REVISION RESPONSE LETTER

**RE: River Bend Crossing Commons
Final Plat**

DATE: December 19, 2019

BARRON LAND
BOUNDARY Δ MAPPING Δ SURVEYING Δ CONSTRUCTION
2790 N. Academy Blvd., Suite 311 P: 719.360.6827
Colorado Springs, CO 80917 F: 719.466.6527
www.BARRONLAND.com
PROJECT No.: 17-054 SHEET 1 OF 4

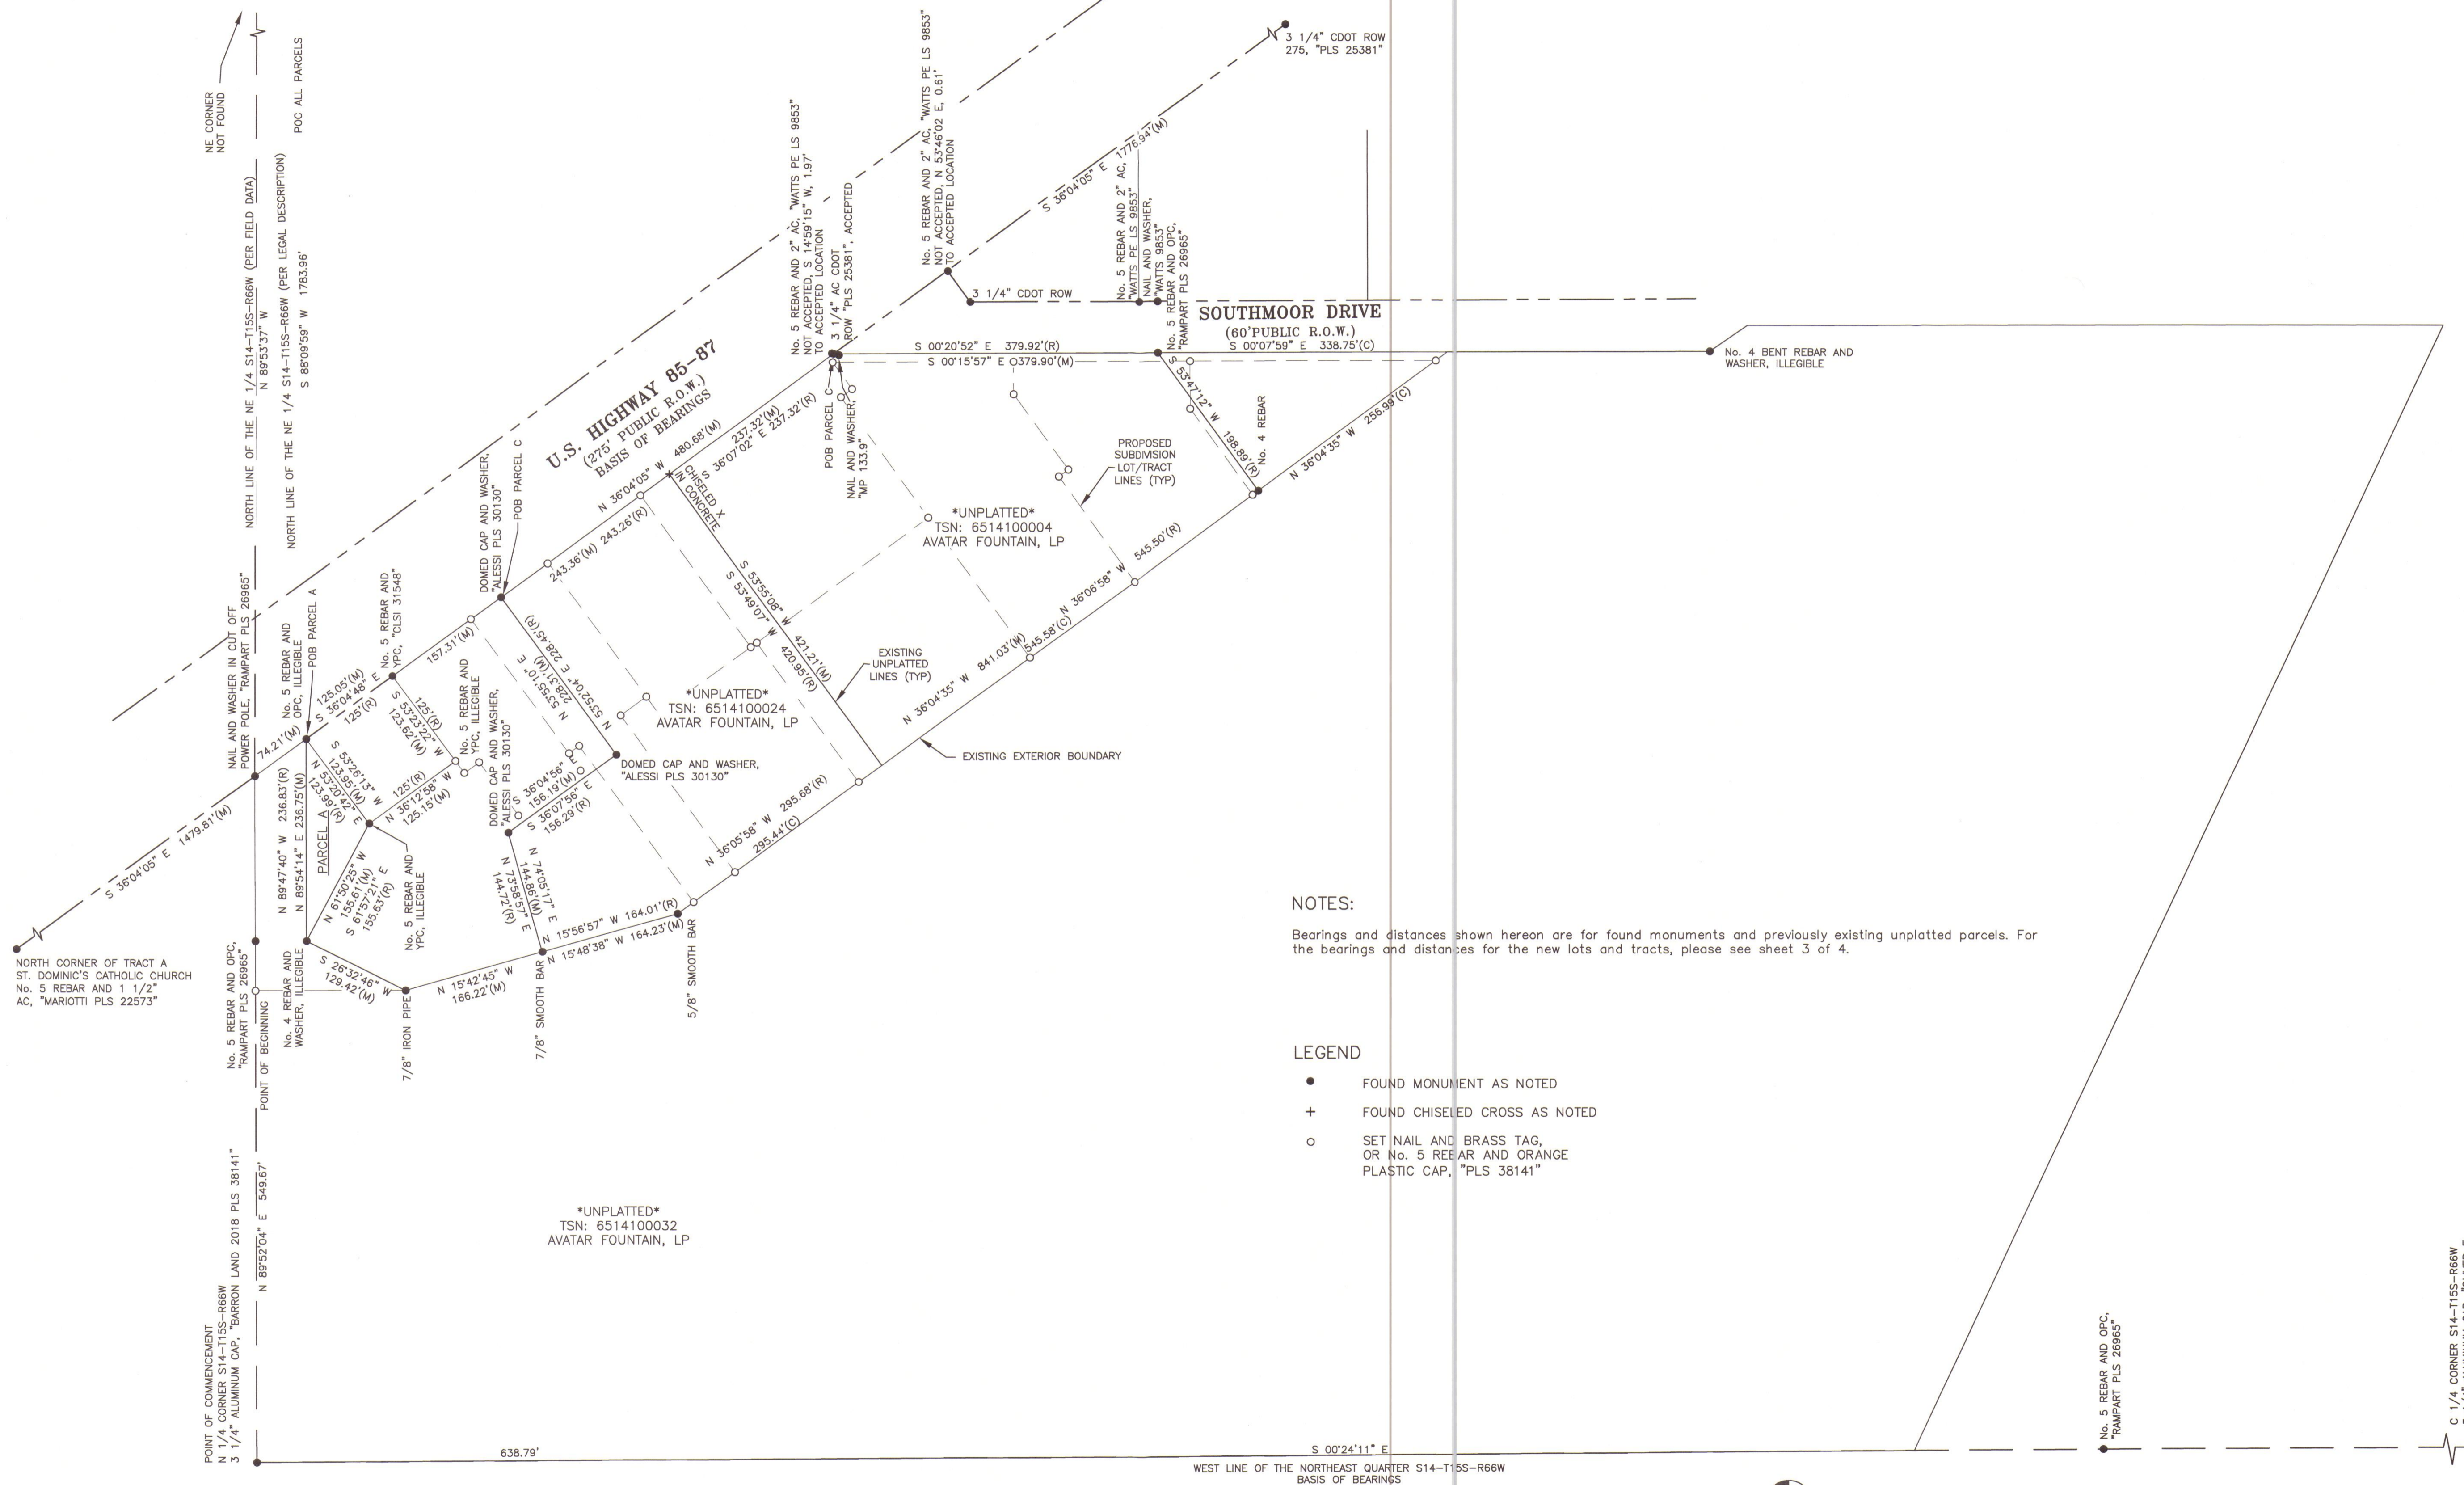
1. *Please refer to Surveyor's Note No. 18, it does not appear as if this note is applicable to this project. We suggest it be deleted. **10' being dedicated by this plat is shown and only referenced in notes now for total acreage of lots, rows, etc...***
2. *Refer to notes regarding Sheet 3 of 4 and Sheet 4 of 4 pertaining to specific utility easements required for water transmission and distribution facilities and wastewater collection and conveyance facilities. Some notes from those documents are pertinent. Therefore, we suggest that the Surveyor's Notes include one that reads, "Refer to Sheet 3 of 4 and Sheet 4 of 4 for specific easements to be granted for the use of the Security Water District and the Security Sanitation District." **Water and sanitary easements will be recorded by separate doc and shown on the plat***

PROJECT No.: 17-054 SHEET 2 OF 4

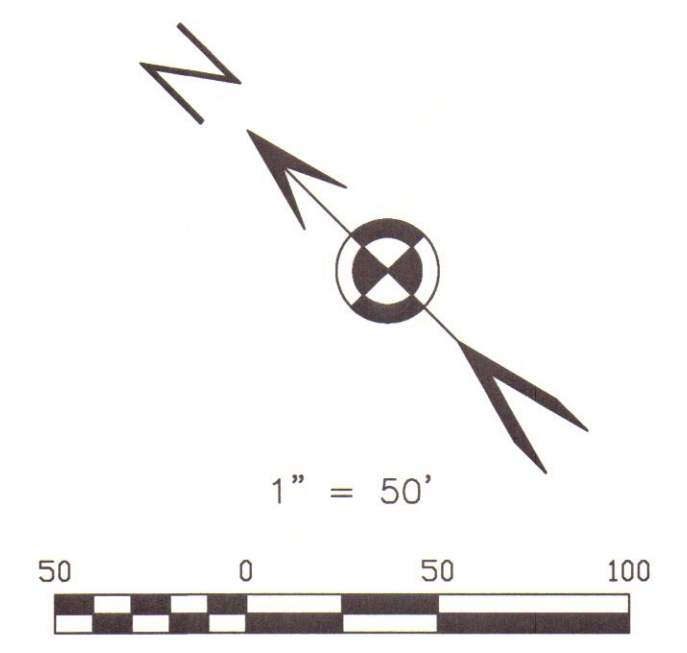
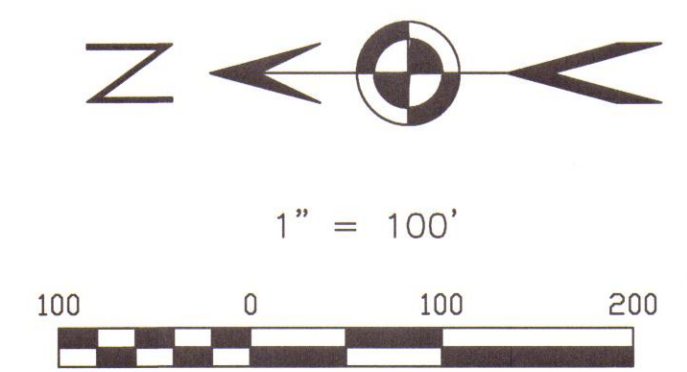
1. *North corner in the Basis of Bearing statement does not agree with that shown on the monumentation detail, sheet 2. Please review and revise as appropriate. **Note on sheet 2 revised.***

BARRON LAND
 BOUNDARY & MAPPING & SURVEYING & CONSTRUCTION
 2790 N. Academy Blvd., Suite 311 P: 719.360.6827
 Colorado Springs, CO 80917 F: 719.466.6527
 www.BARRONLAND.com
 PROJECT No.: 17-054 SHEET 3 OF 4

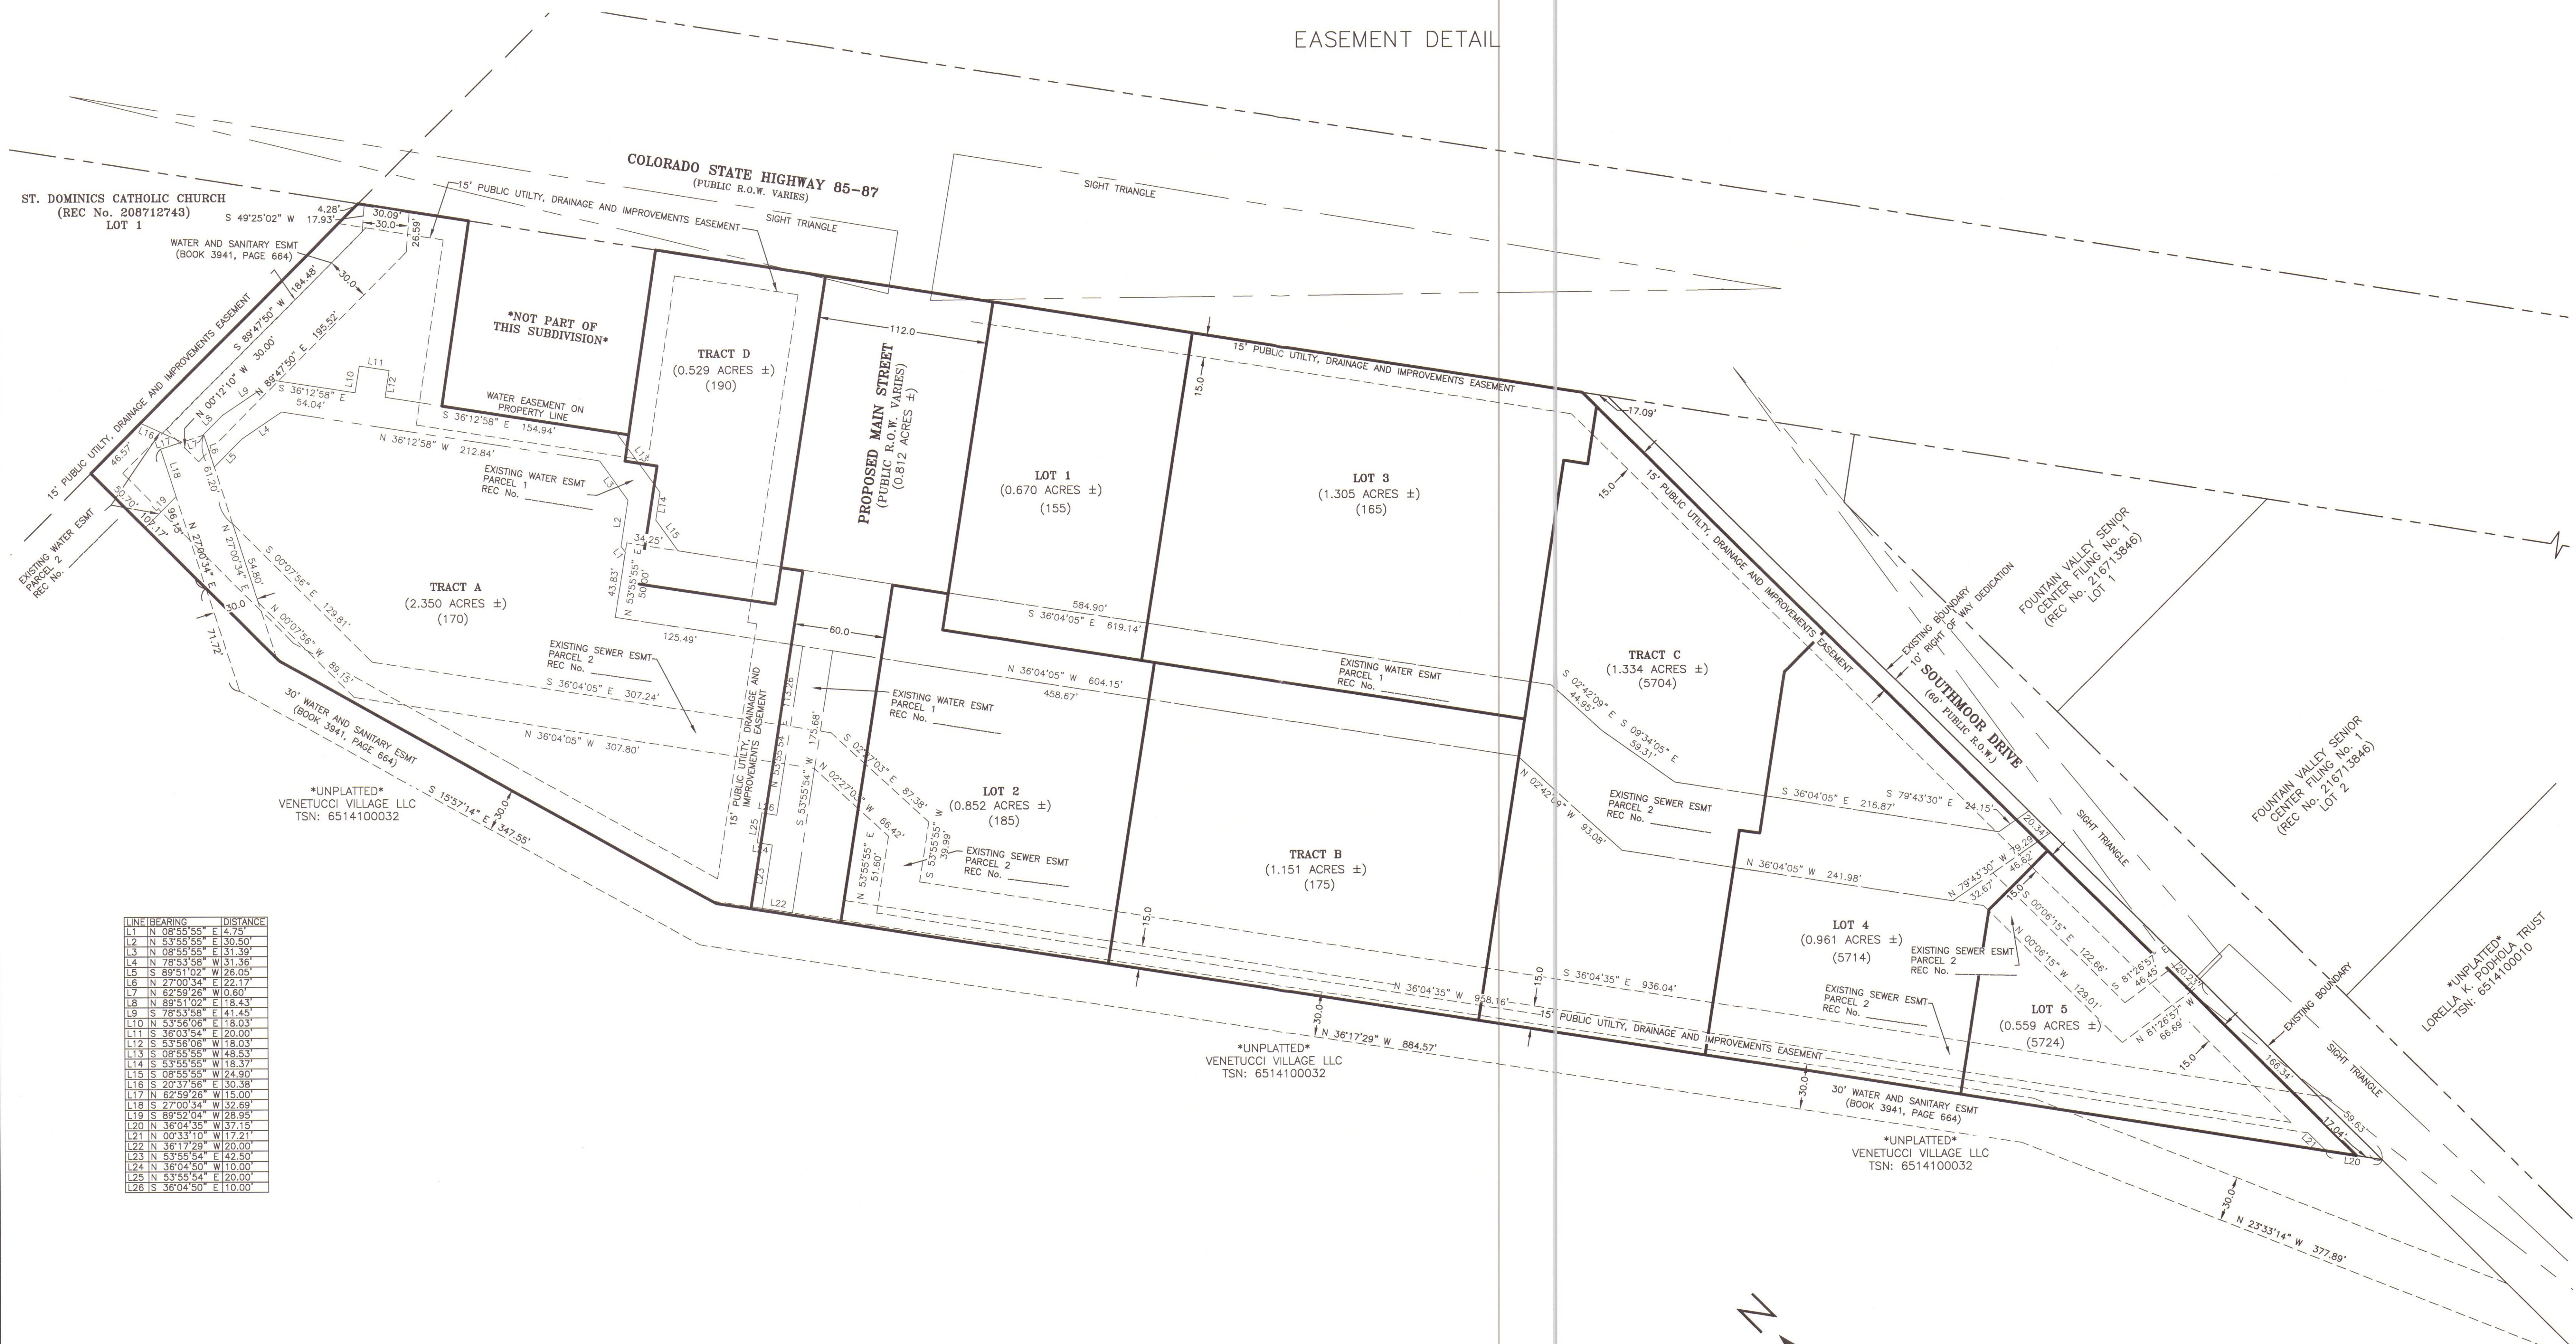
1. *Refer to comments regarding the wastewater collection and conveyance pipelines and water transmission and distribution systems presented in the document captioned, "Riverbend Crossing Commons, Utility Construction Drawings," 5 sheets, with date of latest revision of May 15, 2019. Revise subdivision Final Plat, Sheets 3 and 4 to reflect the required easements for that utility infrastructure. **Water and sanitary easements will be recorded by separate doc and shown on the plat.***

2. *Please provide the recordation information on the existing wastewater pipeline easement located within the bounds of this Final Plat and adjacent to and identified hereon as a 30-foot wide undefined tract. **Easement information has been updated to current layouts and existing easements.***

3. *Please make a determination as to the possible vacation or quit claim of the existing Access Easement recorded in Book 2472 at Page 228 prior to recordation of this plat. Is there any rationale that this easement should remain as an encumbrance on Tract A? Based on our knowledge of this easement, it appears it would be in the best interest of the project that it be eliminated before this plat goes to record. **This easement and restriction has been replaced with a new easement and access agreement and is noted in the surveyor's notes.***

3. *Show property monumentation on Sheet 3 as well. **The whole purpose of having a monument page is to keep the clutter down on the plat. If we wanted to show all the monuments on sheet 3, there would be no need for the monument page! We would just clutter the heck out of sheet 3. We have a note stating to see sheet 2 for monumentation.***

Figure 5

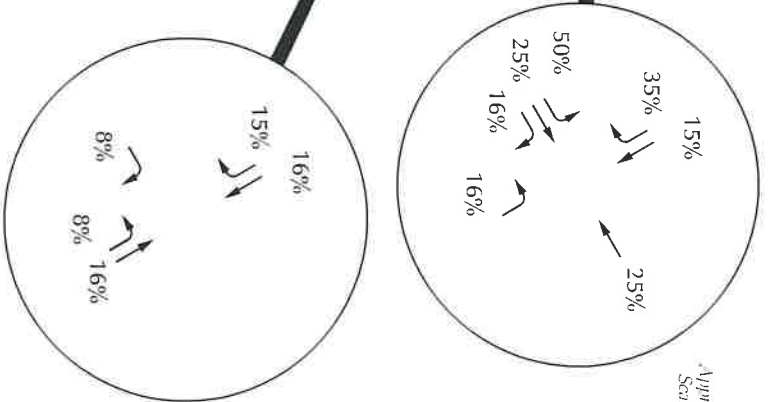
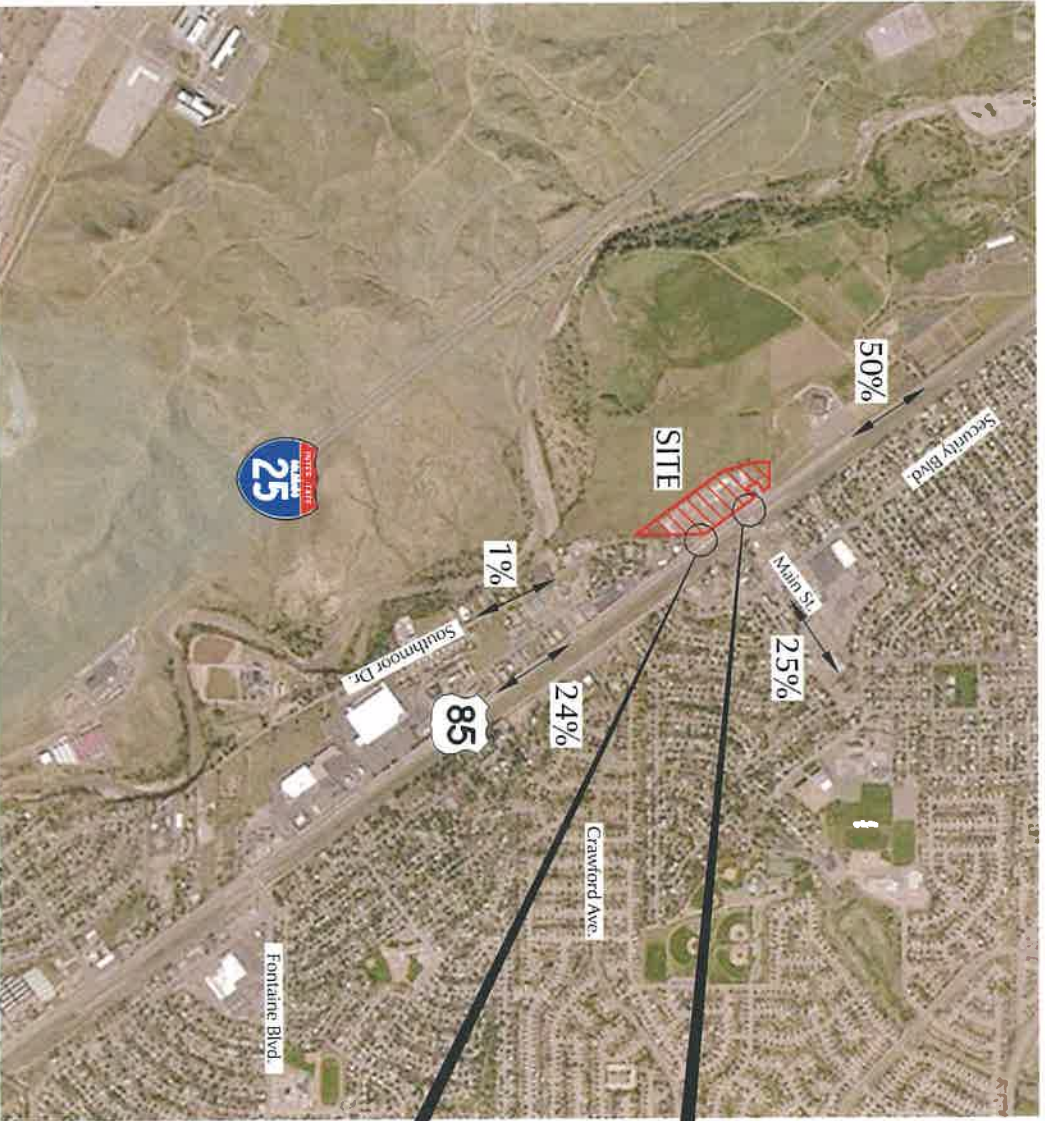
- 1. Resubmit with the full Table 2 data shown. Printed copy does not show the full extents of the table.*
- 2. Revise Figure 5 trip distribution by increasing the percent traffic at the Southmoor access to the commercial development. Figure 5 assumes 8% of site generated traffic using the Southmoor access. However, existing traffic counts (Figure 4) shows roughly 36% of in/out traffic use Southmoor Drive to access the commercial site. Redevelopment is likely to see similar results.*
- 3. Identify the distance between the commercial access and the proposed residential roadway access on Southmoor Drive. State if the residential access requires a southbound storage lane. The access/intersection spacing must be greater than any required turn lanes or queueing.*

Traffic report has been revised and re-submitted. Jeff w/ LSC has reached out to Jeff Rice, who did the last review to remedy any comments.
